RE: 2103 Los Luceros Rd NW
Grading & Drainage Plan
Engineer's Stamp Date: 09/08/2025
Hydrology File: H12D025
Case # HYDR-2025-00324

Based upon the information provided in your submittal received 09/08/2025, the Grading & Drainage Plan is **not** approved for Building Permit. The following comments need to be addressed for approval of the above referenced project:

**GRADING AND DRAINAGE PLAN**  
2103 LOS LUCEROS ROAD NW  
ADRIAN OGLESBY

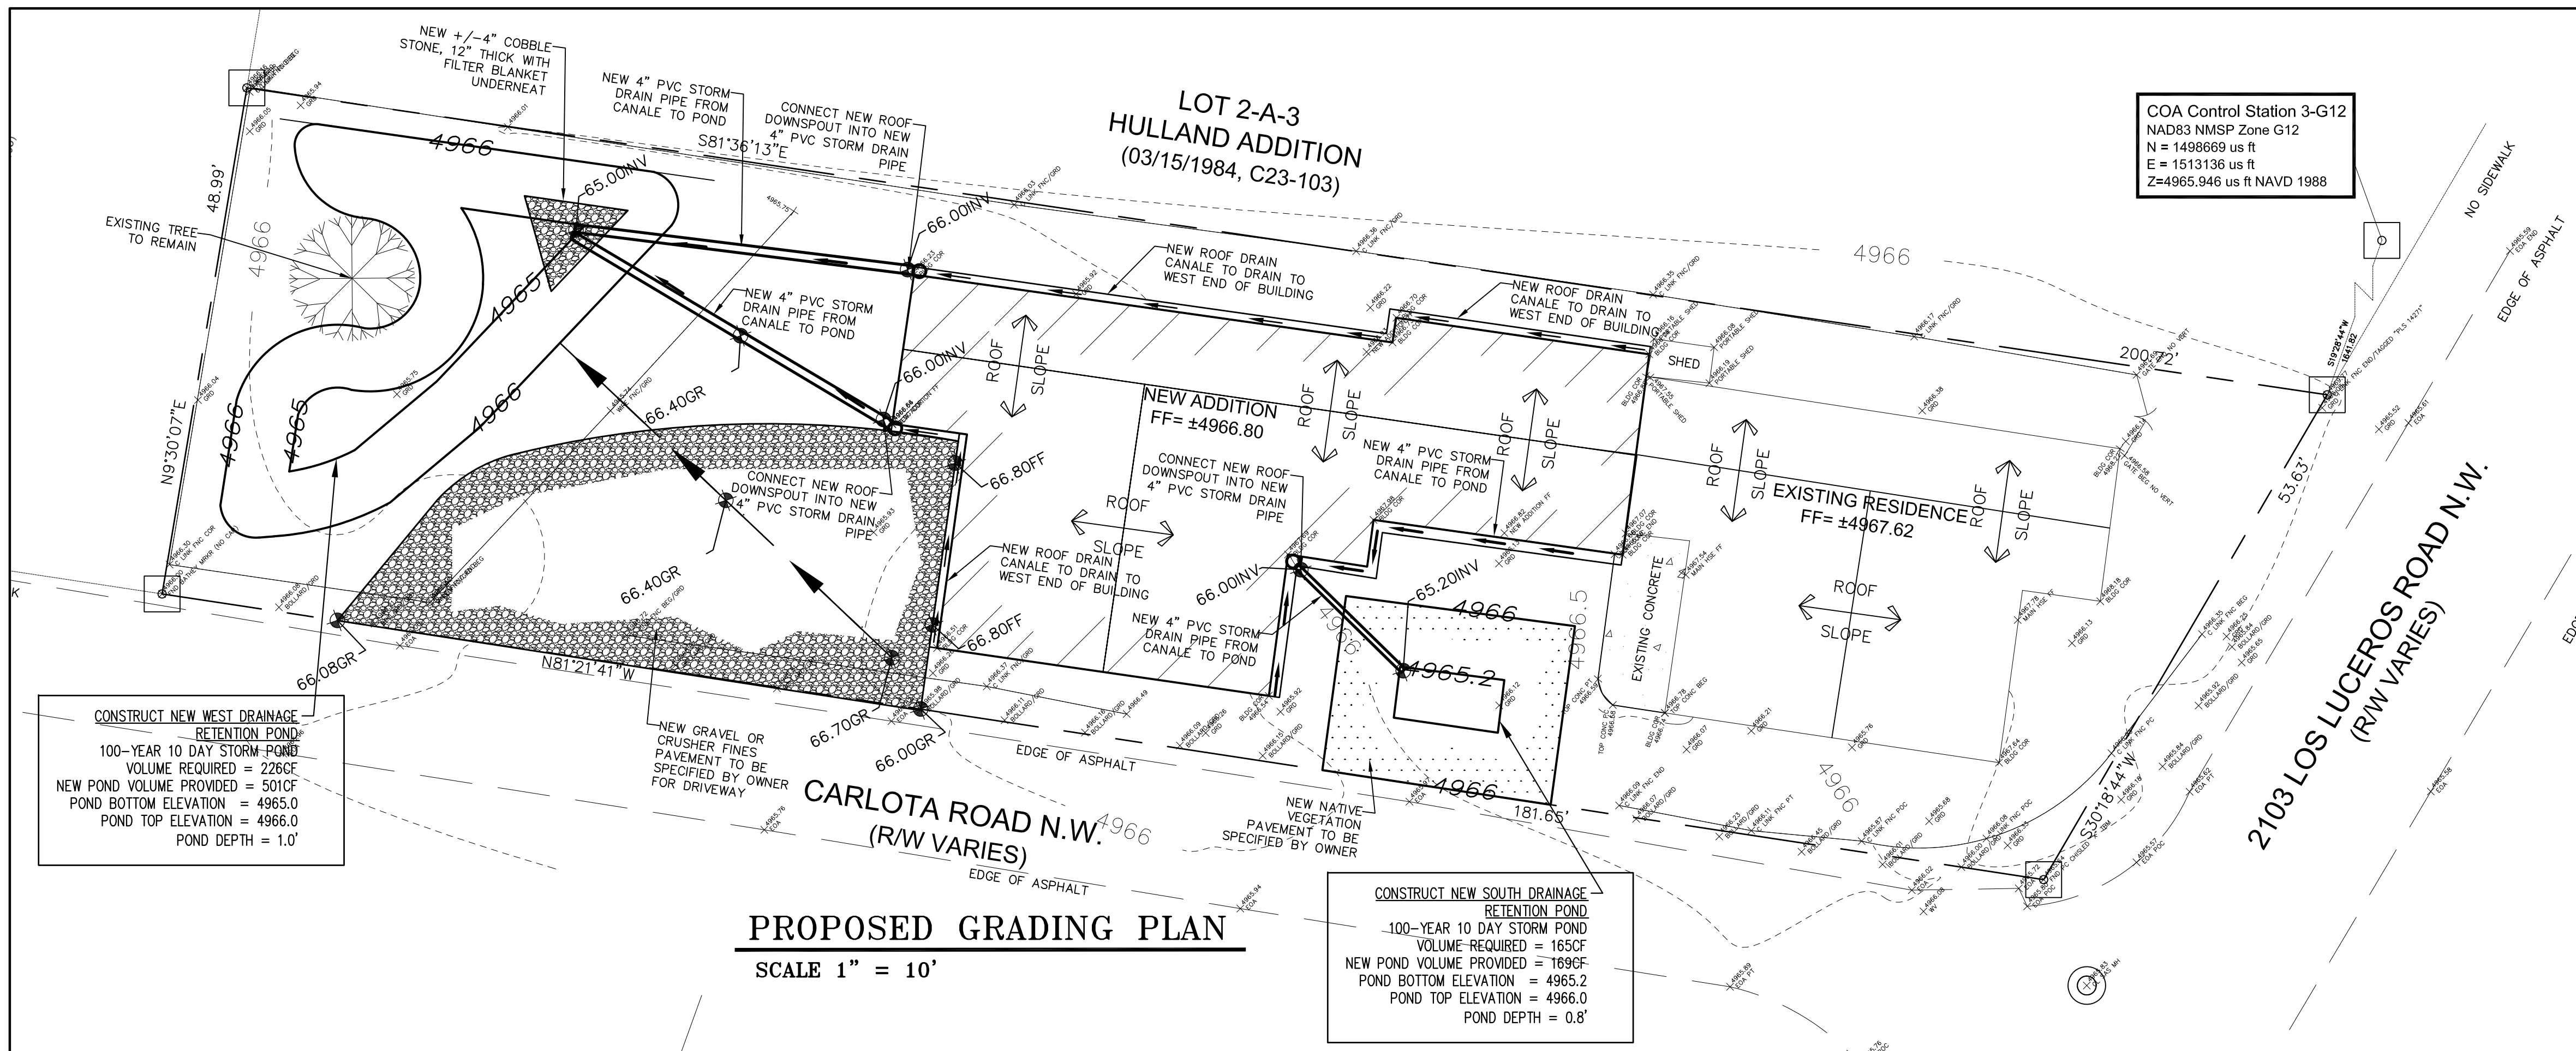
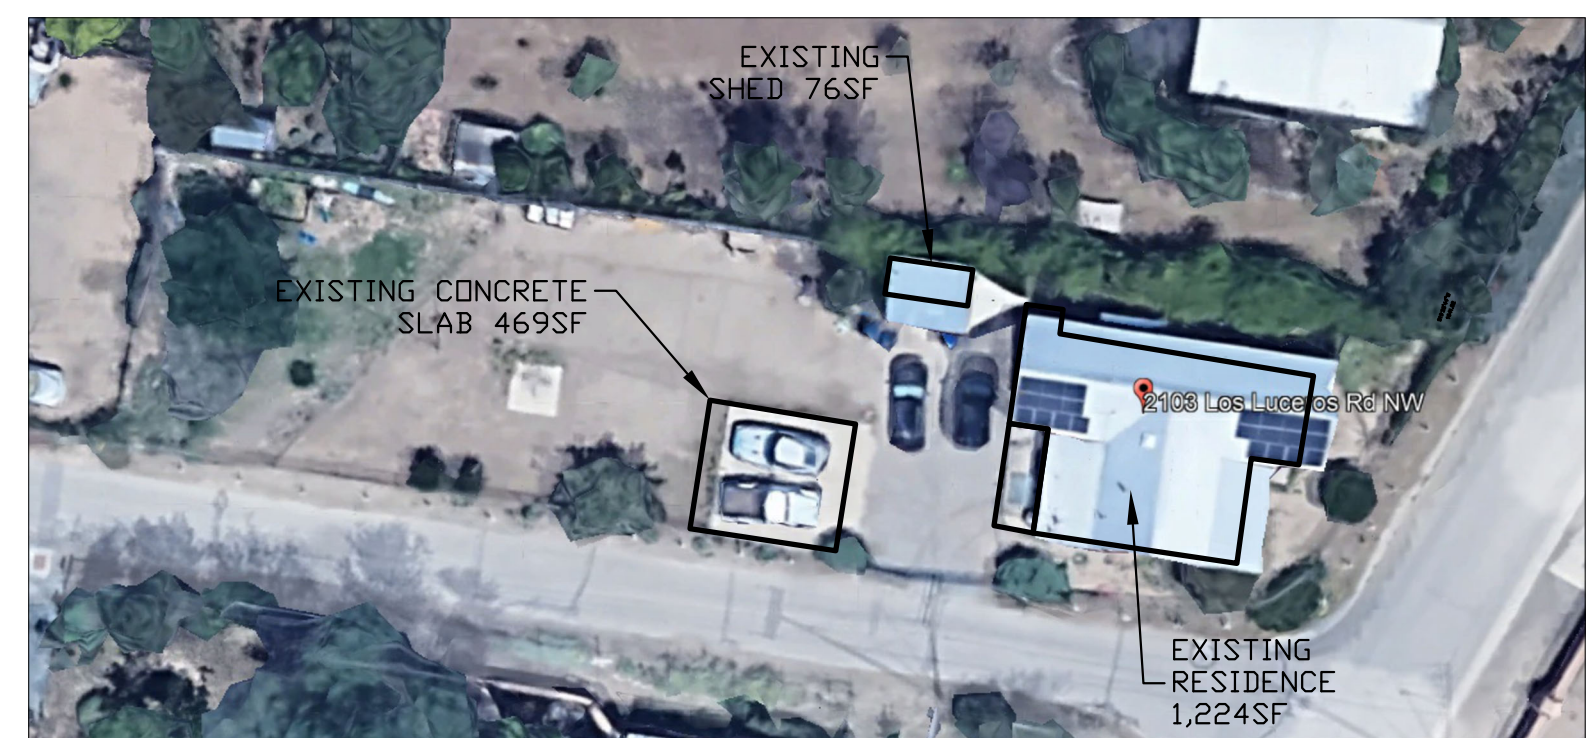
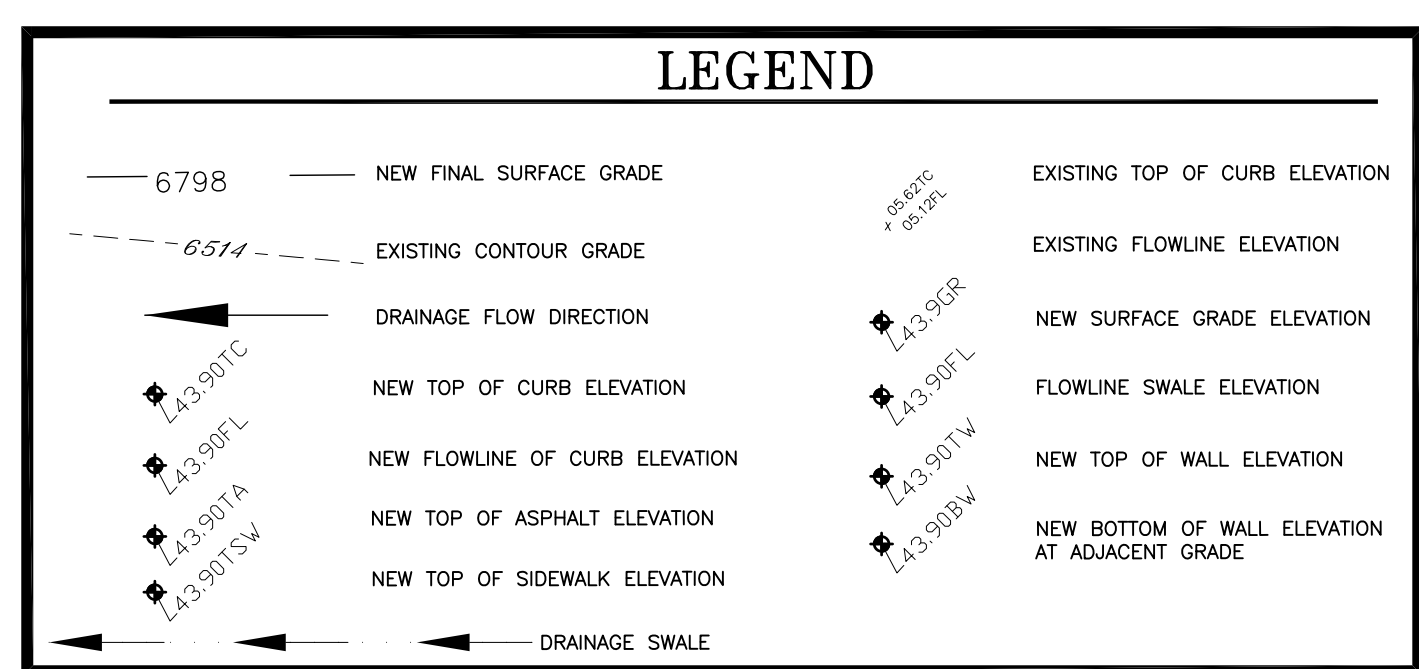
1. Per the 6-5-5-3 of the Sidewalk Ordinance, the property owner of the property is responsible for building the curb & gutter, and sidewalk along Los Luceros and Carlota. The project will have to go to the Development Facilitation Team (DFT) for approval of the Infrastructure List unless a variance is granted. Please show the curb & gutter, and sidewalk on the plans.
2. Please provide the Benchmark information (location, description and elevation) for the survey contour information provided.
3. Since this site is in the Valley region, please follow Article 6-5 Valley Drainage Criteria of the DPM. The following conditions must be applied to the site:
 - A permanent perimeter wall or barrier around the development is required to contain the 100 year 24 hour storm developed runoff
